Online Comment

Application H18-0671-19
Location 36 PETTS LANE SUTTON BRIDGE SPALDING PE12 9QB
Proposal Extension and alterations of existing house. Existing outbuilding to be converted into annexe and buildings linked together with a link building

Name Gregory Watkinson, Conservation Officer
Address C/O South Holland District Council Council Offices

Date Submitted 21-08-19
For/Against Objections

PROPOSED EXTENSIONS AND ALTERATIONS
TO HOUSE AND OUTBUILDINGS AT
36 PETTS LANE SUTTON BRIDGE FOR
THE BUNN FAMILY

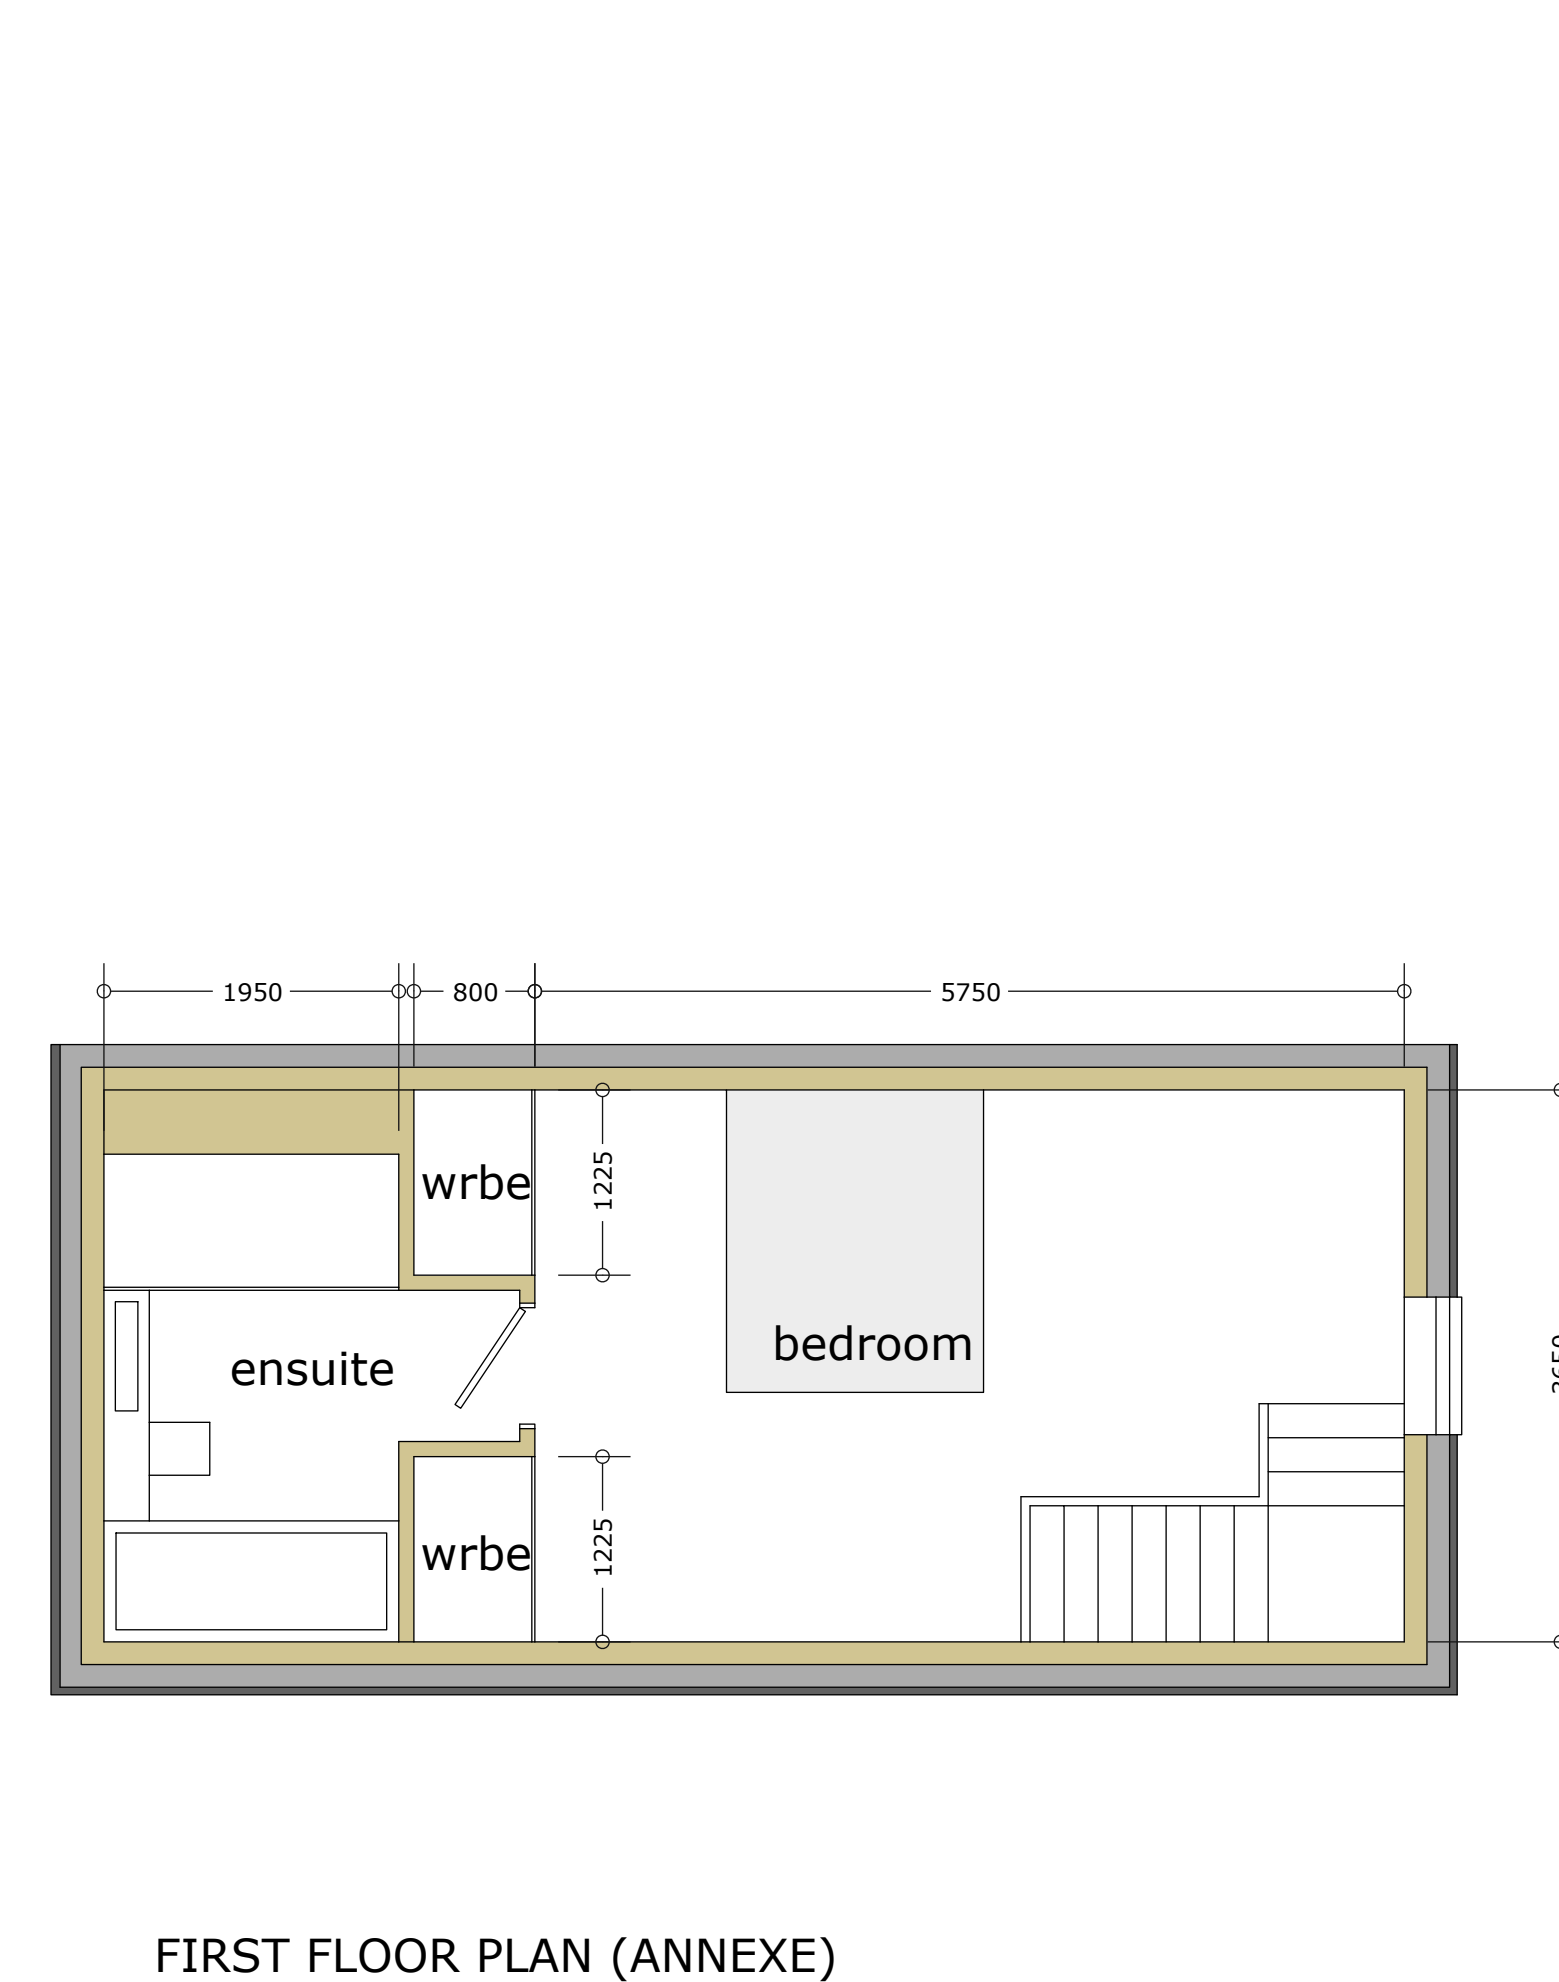
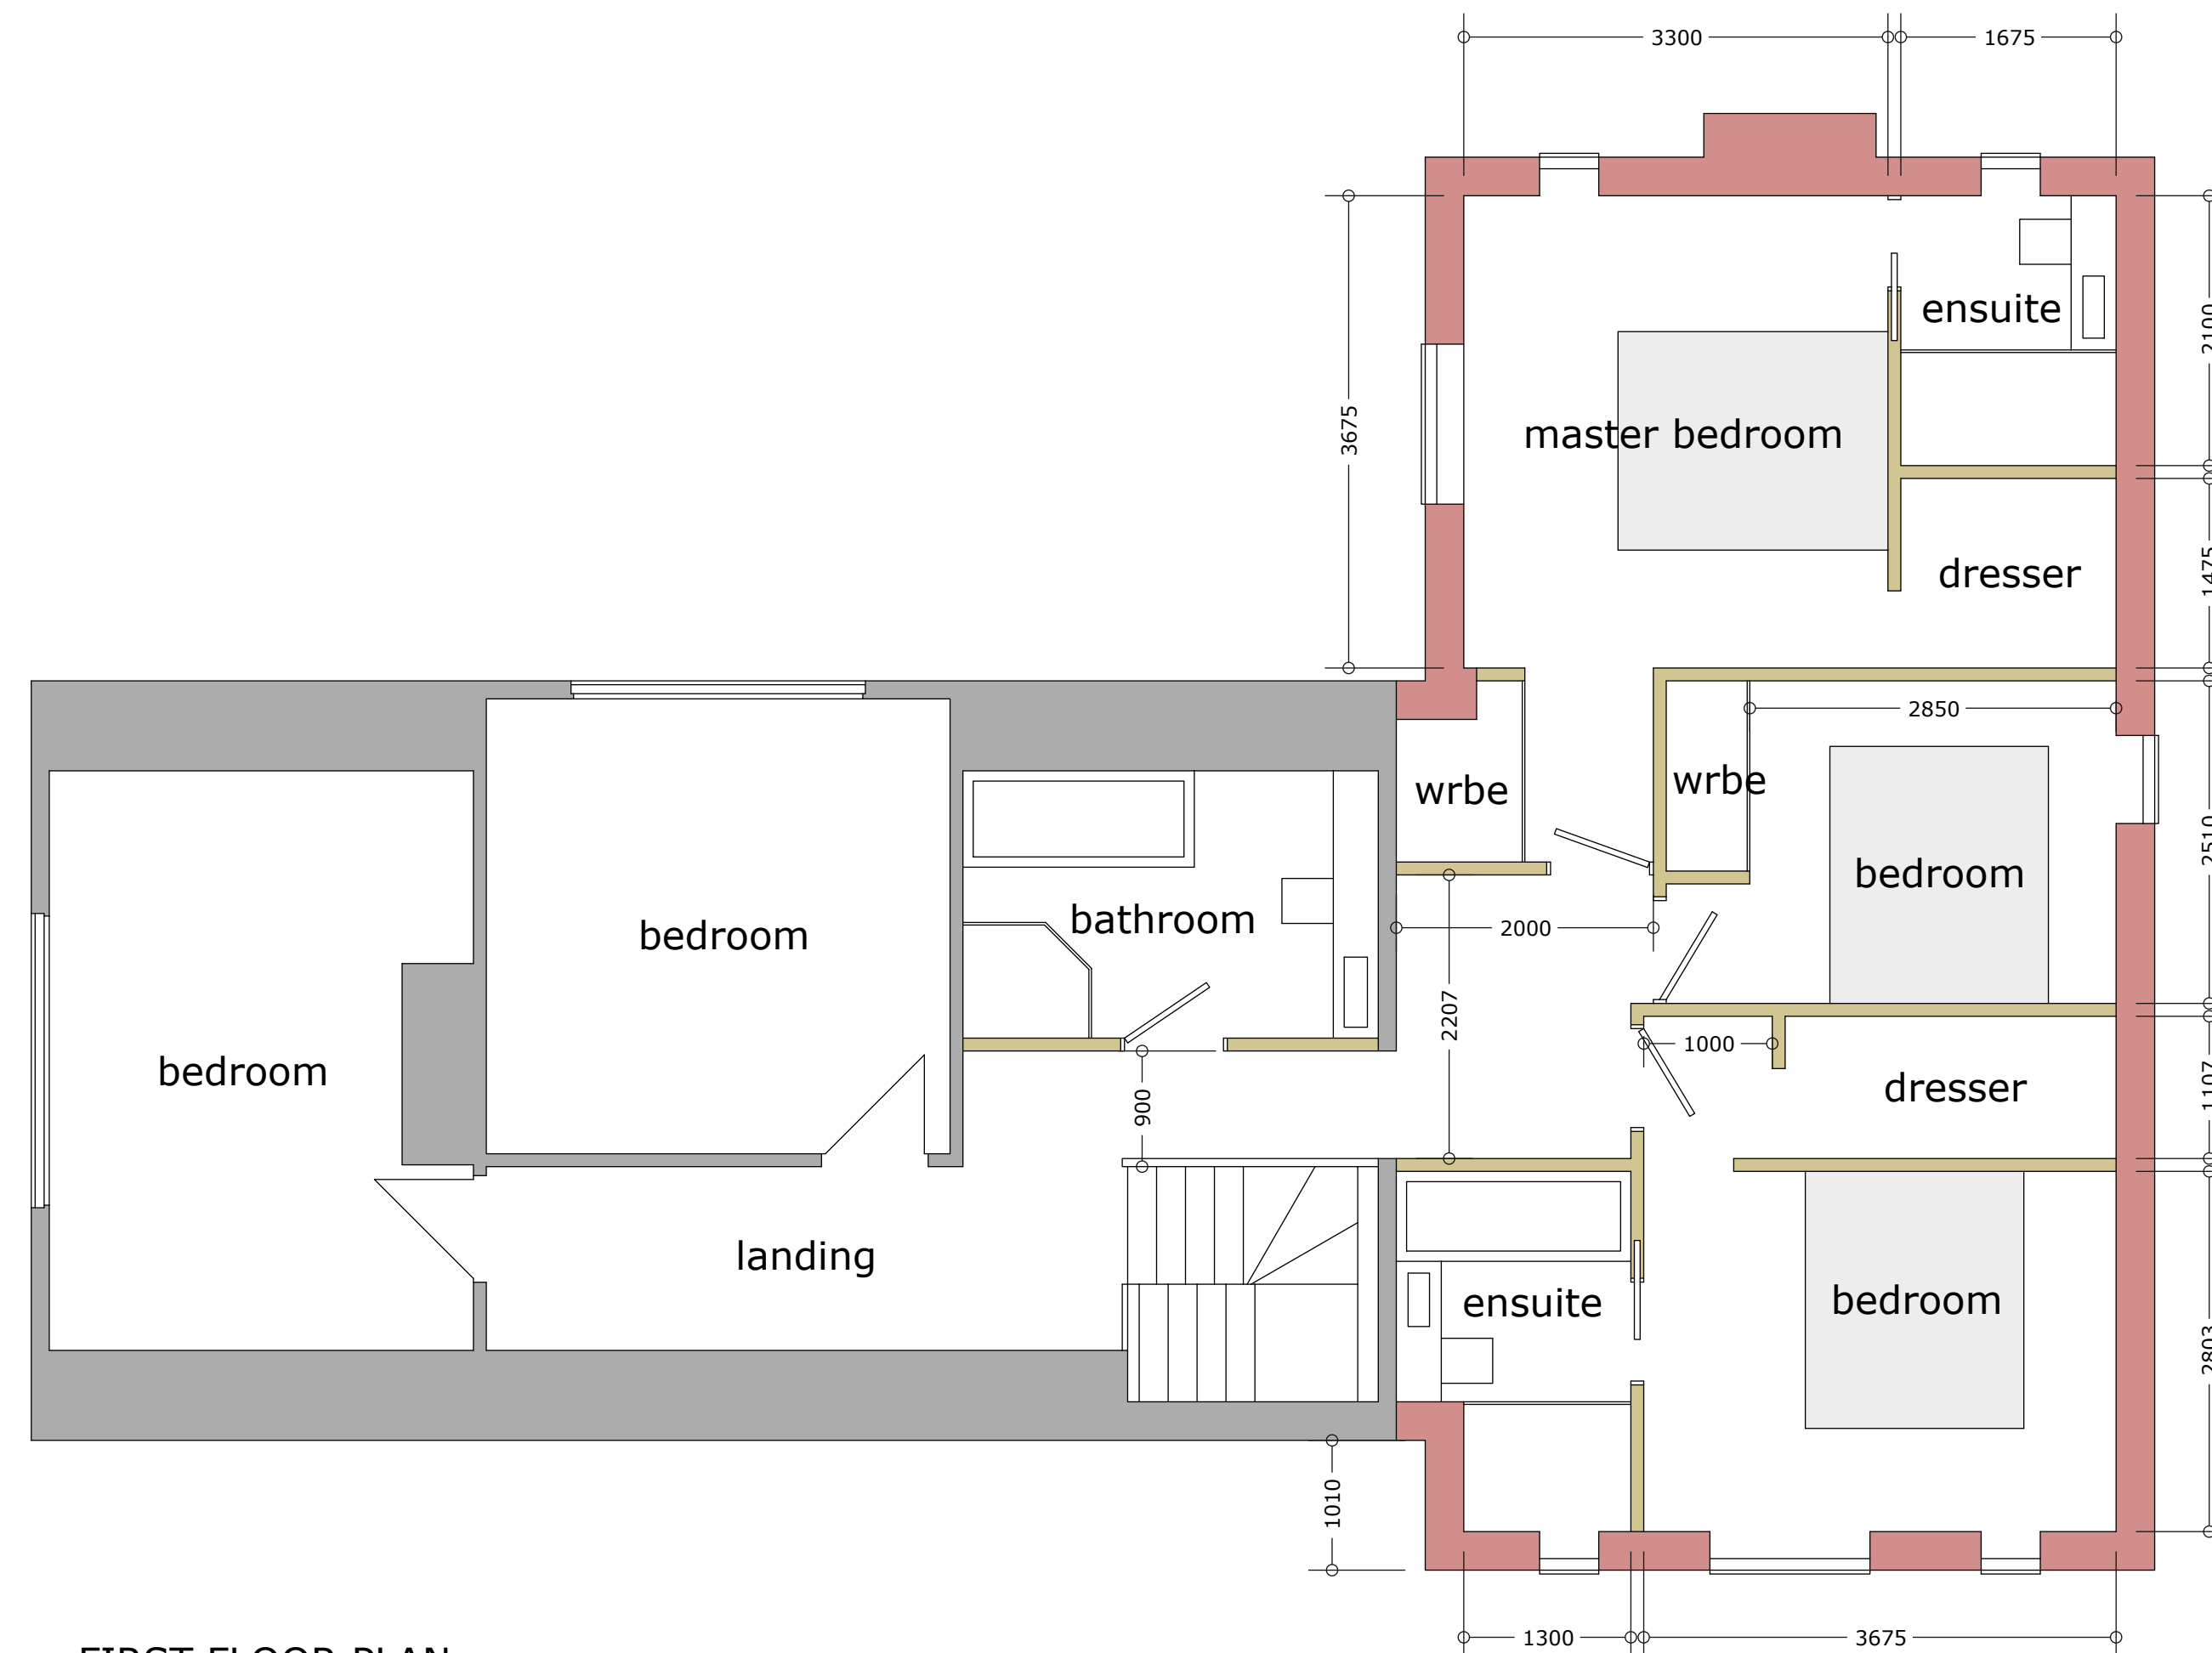
Whilst I do not have an issue with the principle of extending this property, the current plans propose works which would heavily modify the original property and would diminish it into appearing as a wing of a more modern structure. This coupled with the reordering and replacement of windows and doors and the removal of a pair of chimneys would mean the proposals would not be in sympathy with the site's history, rural location or agricultural character.
